Your ref:
Our ref: 24/00200/LDP
Please ask for: Mrs Lesley Raby
Direct dial: 01553 616818
E-mail: borough.planning@west-norfolk.gov.uk

Details: **Lawful Development Certificate: To enlarge kitchen and dining area. at Open View The Row West Dereham King's Lynn Norfolk**

"OPEN VIEW"

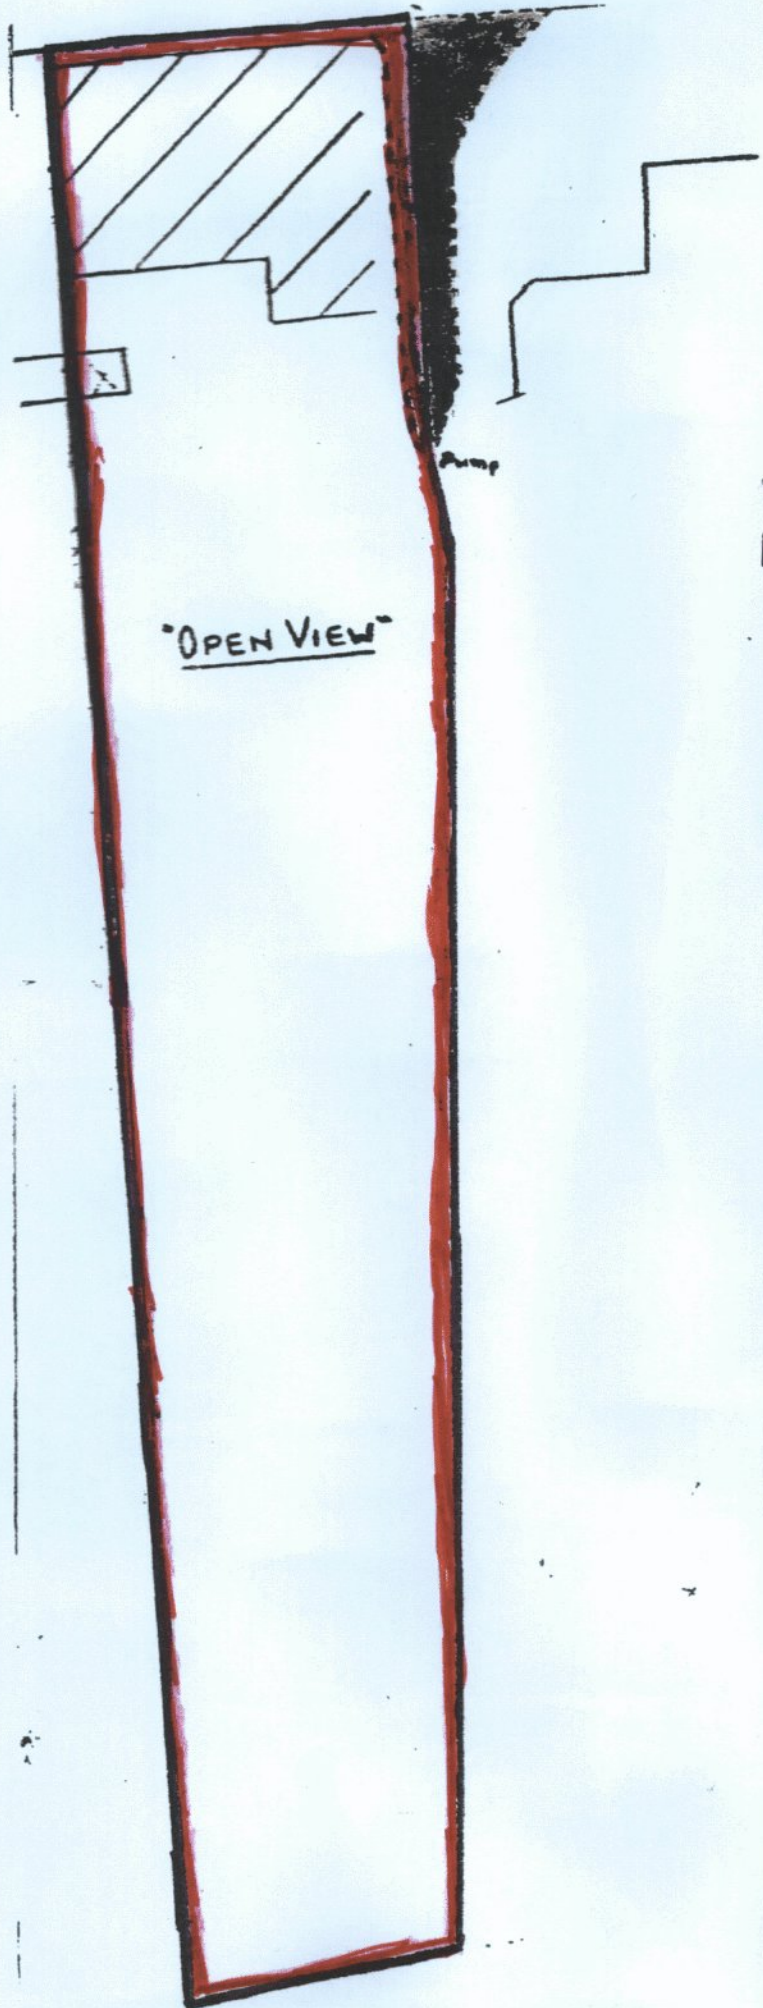
1. The application fee of £129.00 is payable.
You can pay your fee in the following ways:-
 1. Send a cheque made payable to "BCKLWN" - please quote the application reference number on the back of the cheque.
 2. BACS - Account Number 00148342 Sort Code: 20 17 68 - please quote the application reference number on your payment.
 3. Telephone 01553 616234 and pay by debit or credit card.
2. The location plan provided show the red line drawn around the neighbouring property.

Please provide a scaled location plan with the red line drawn around the boundaries of 'Open View' as the application site.
